MEMORANDUM

FROM: C.H. Moss, P.E.

DATE: October 8, 2024

RE: Foundation Plan Drawing No. 3786 S-1, S-2, S-3, S-4  
Baucom Business Plaza  
Fuquay Varina, NC

DRAWING NUMBER	
3786	
SHEET	OF:
S-1	4

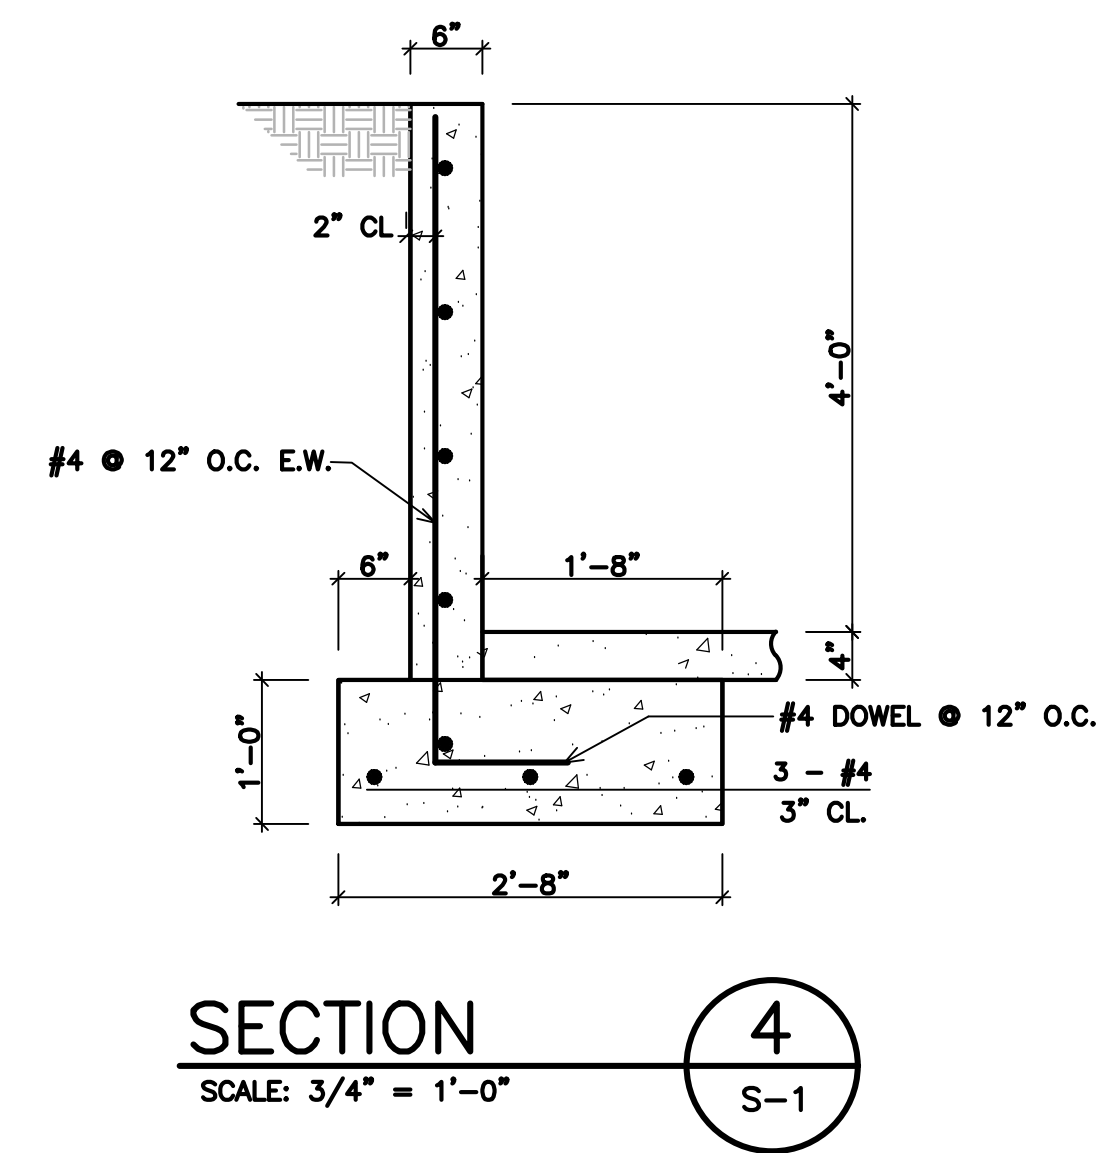
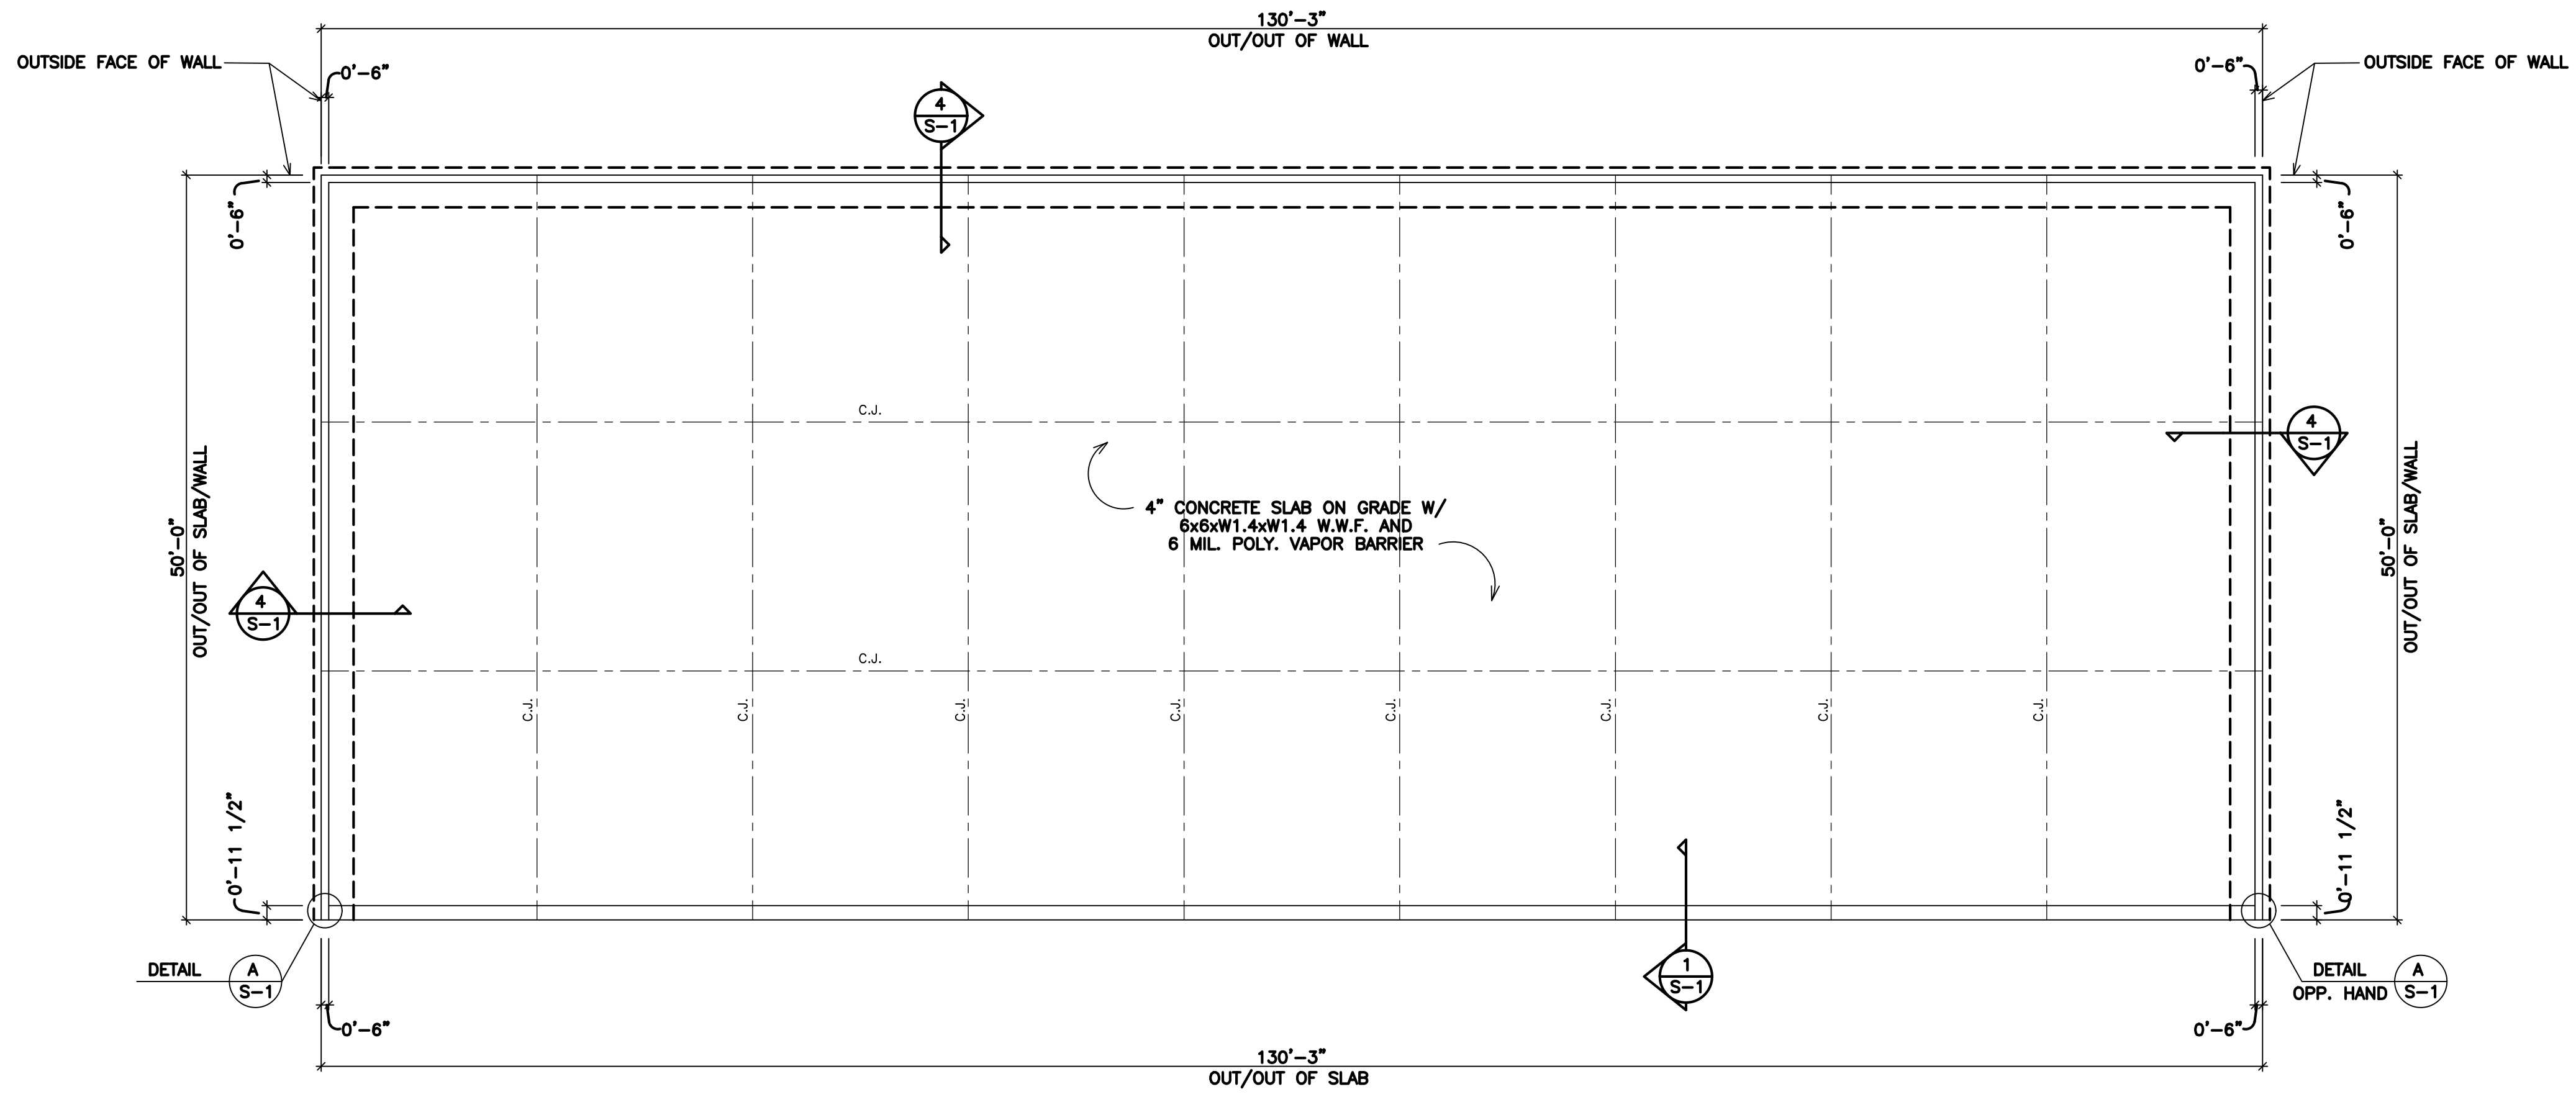
It is acceptable to use 3000 psi fibermesh concrete with a minimum dosage of 1.5 pounds per cubic yard in lieu on welded wire fabric as shown on the foundation plans for the Buildings shown on the referenced Drawings.
